Re: Judge Orr Road Commercial Park Traffic Impact Study

Please see the JR Engineering comment responses to the comments received on April 22, 2026 for the Judge Orr Road Commercial Park Traffic Impact Study. The comment responses are in red italics.

Figure 1 - Vicinity Map

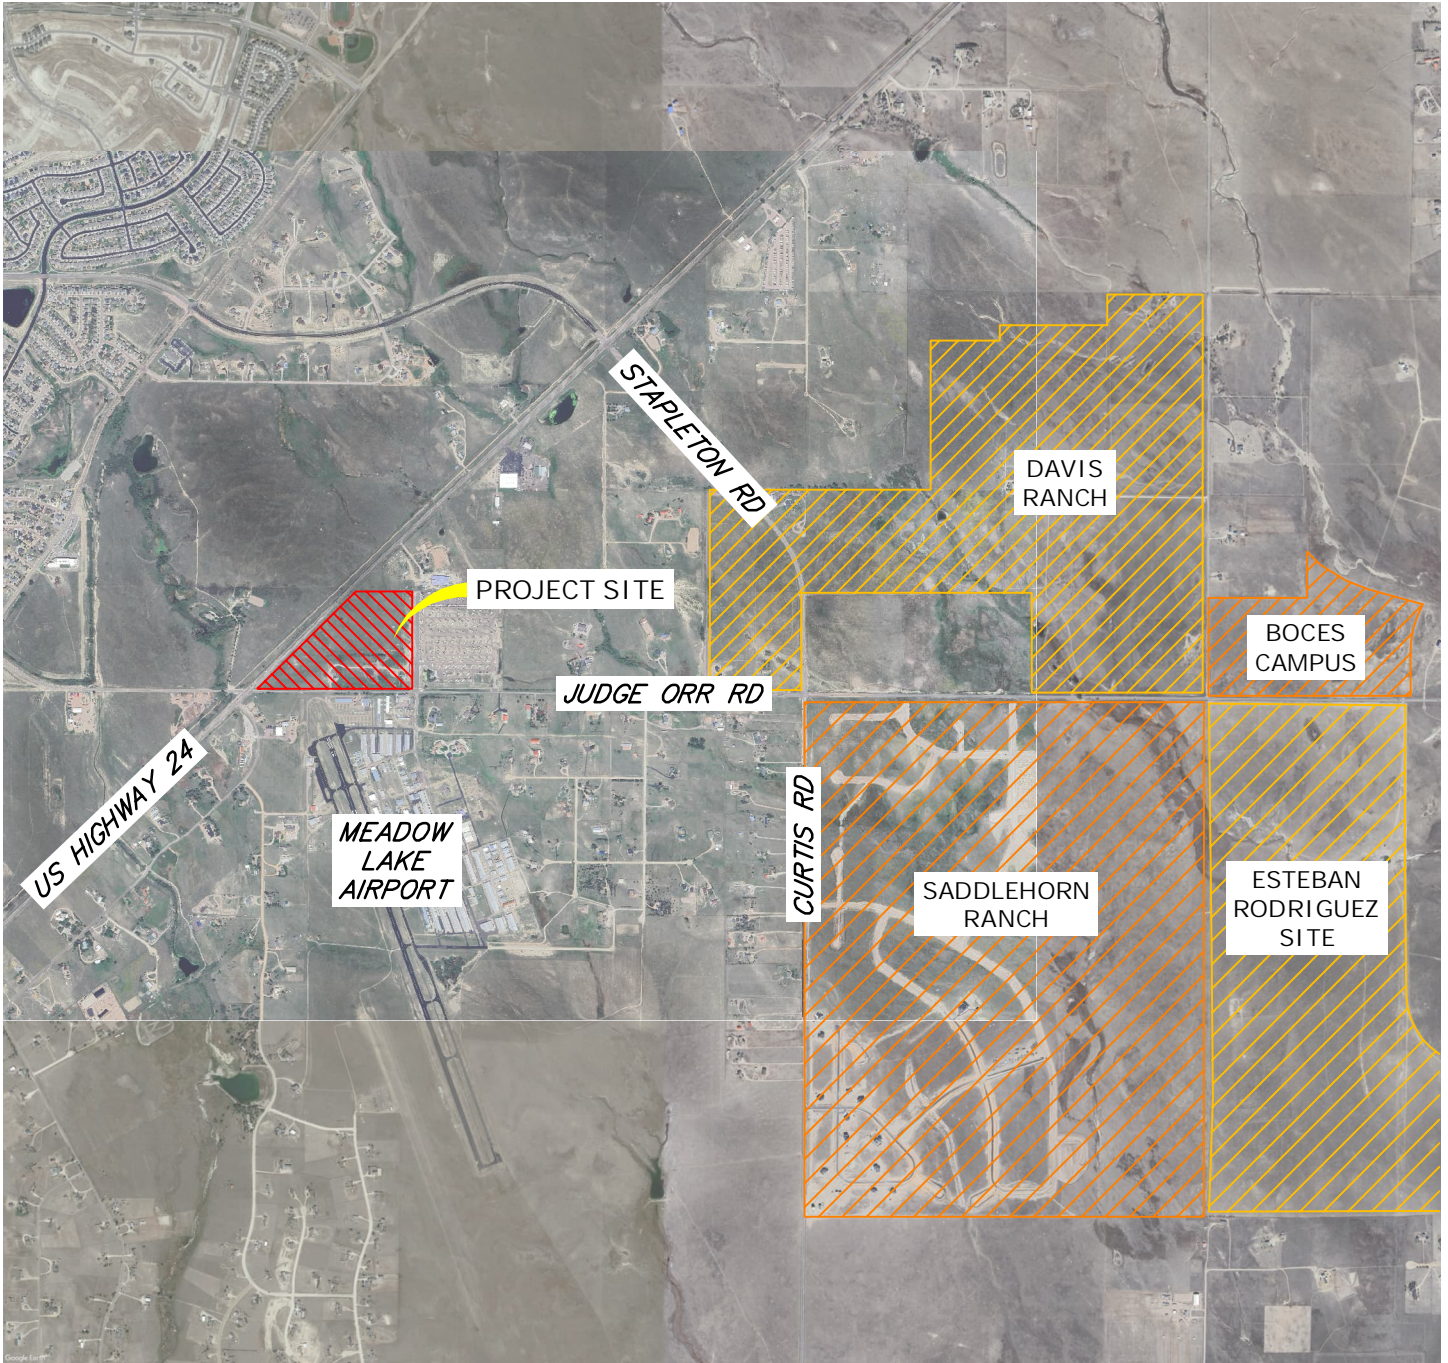
7. Provide exhibit that shows boundaries of these properties in relation to this project.

JR Response: Nearby project boundaries added to Figure 1: Vicinity Map.

Figure 4 - 2028 Opening Day Proposed Lane Geometry

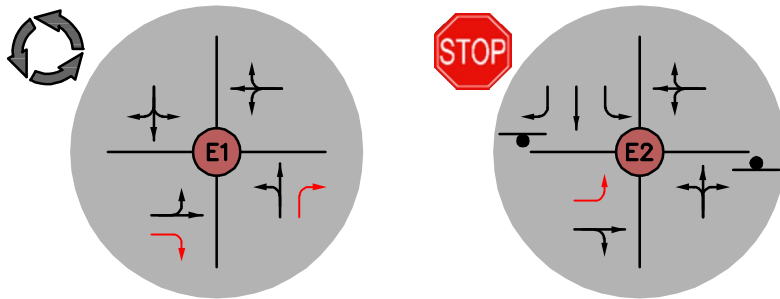
8. Note somewhere in the report that the design of this turn lane will be done at later stages of development.

JR Response: Noted on page 7.
